19 March 2020

**RESPONSE TO SUBMISSIONS  
PROPOSED NEW SYDNEY FISH MARKET - STAGE 2 MAIN WORKS (SSD8925)  
1A TO 1C BRIDGE RD, GLEBE & PART 56-60 PYRMONT BRIDGE ROAD, PYRMONT**

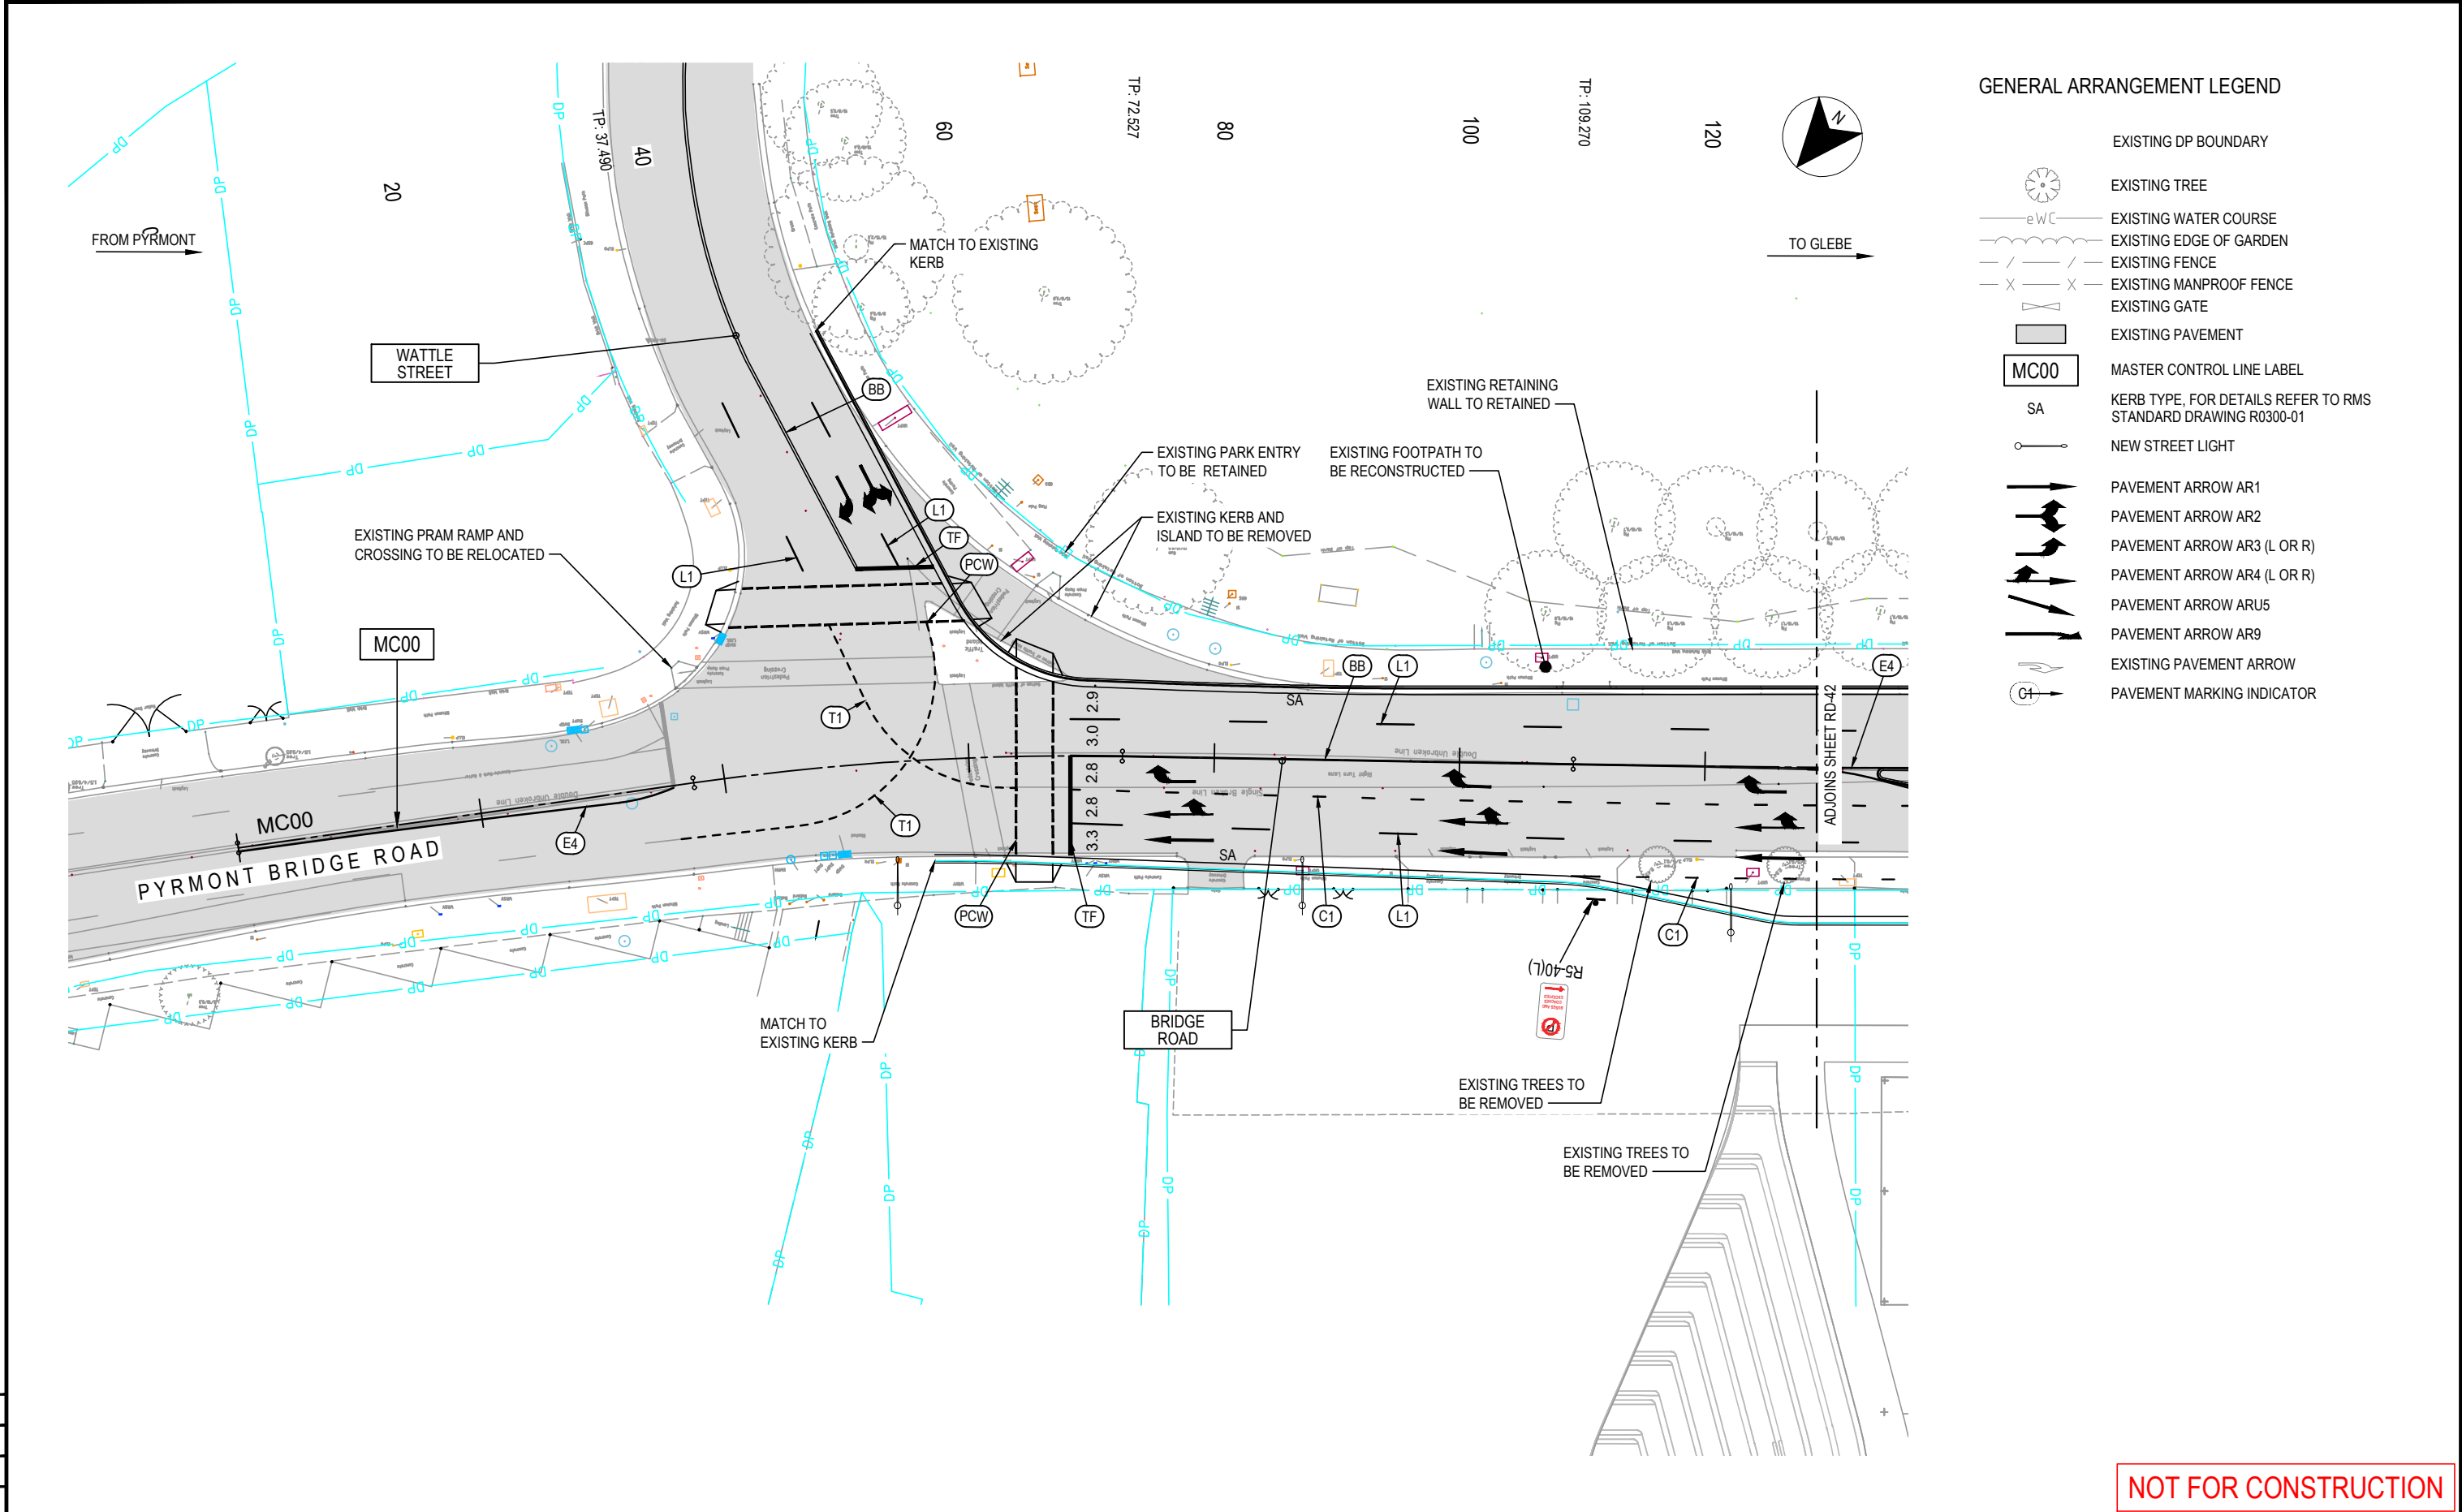
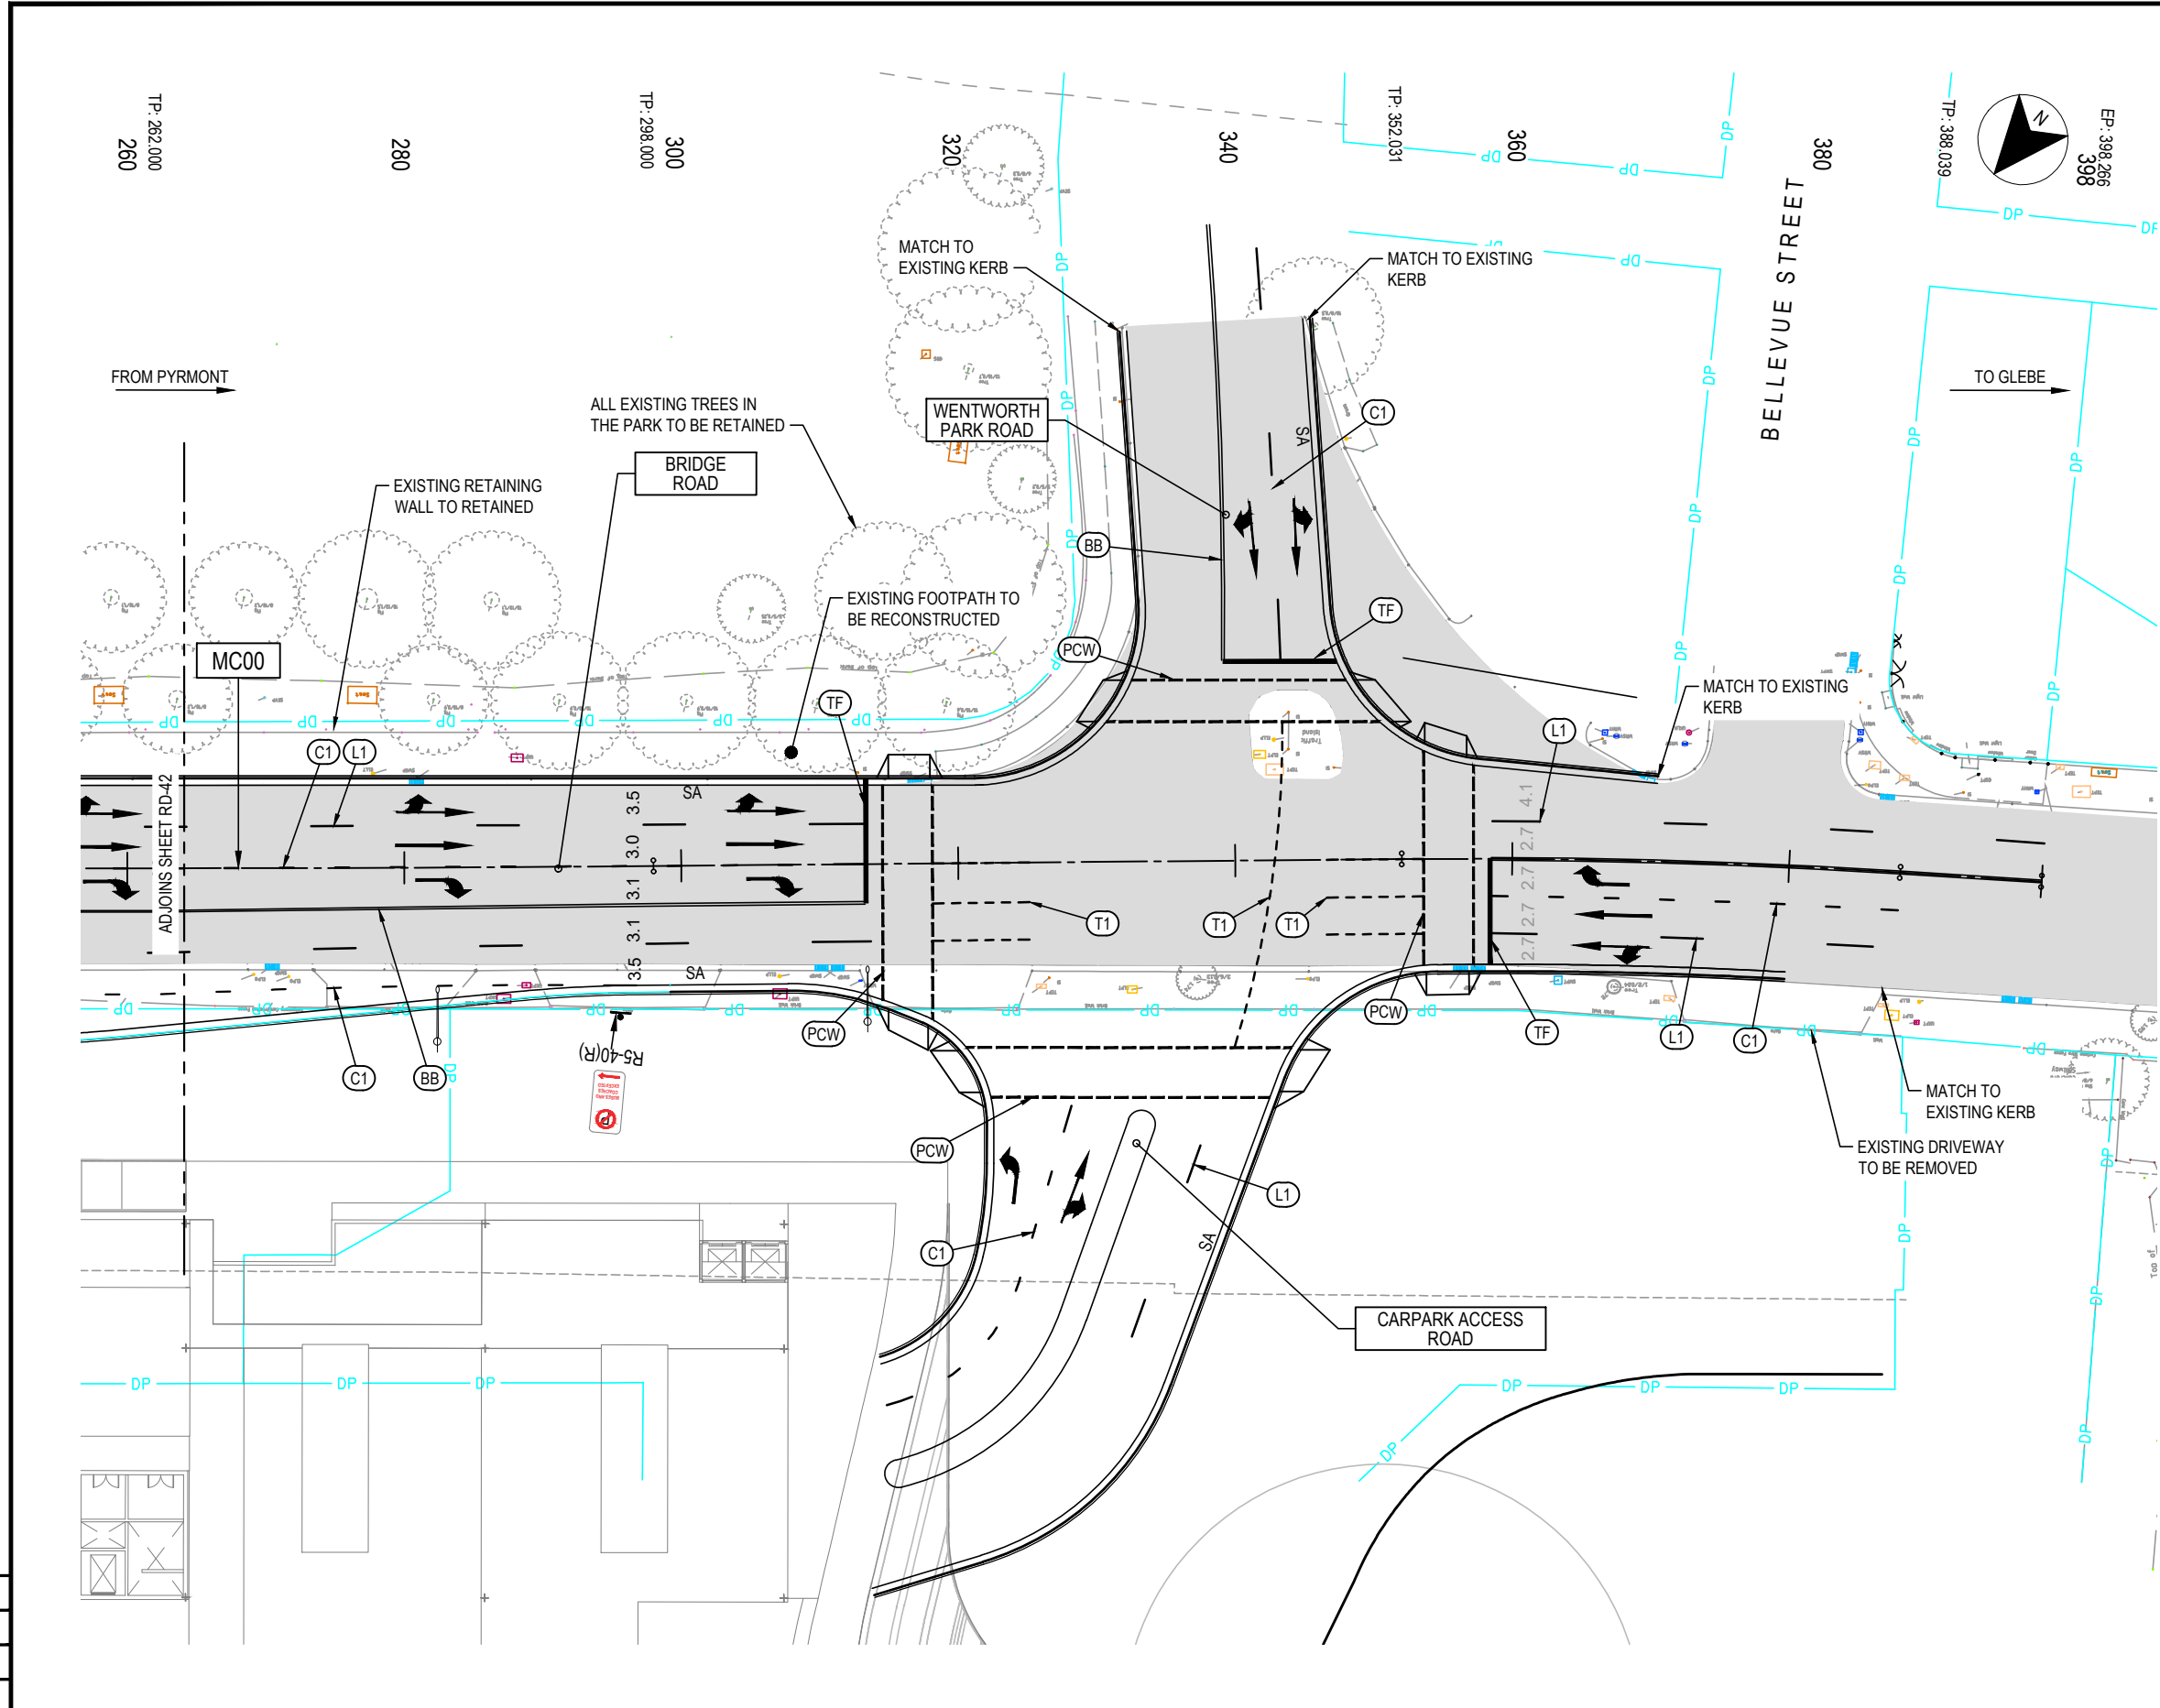
The Response to Submissions (RtS) recommends road network changes adopted for the future scenario model.

- Prior to the commencing any works within the classified road reserve area the proponent must obtain Section 87 and 138 concurrence under the *Roads Act 1993* from TfNSW.

The construction of the road works, new traffic control signal and modifications to the existing traffic control signal within the TfNSW corridor (e.g. Bridge Road and Wattle Street) shall be in accordance with TfNSW requirements. Details of these requirements should be obtained by email at [DeveloperWorks.Sydney@rms.nsw.gov.au](mailto:DeveloperWorks.Sydney@rms.nsw.gov.au).

Detailed design plans of the proposed works are to be submitted to TfNSW for approval prior to the issue of a Construction Certificate and approval obtained prior to commencement of any road works that impact upon TfNSW road corridors. Please send all documentation to [development.sydney@rms.nsw.gov.au](mailto:development.sydney@rms.nsw.gov.au).
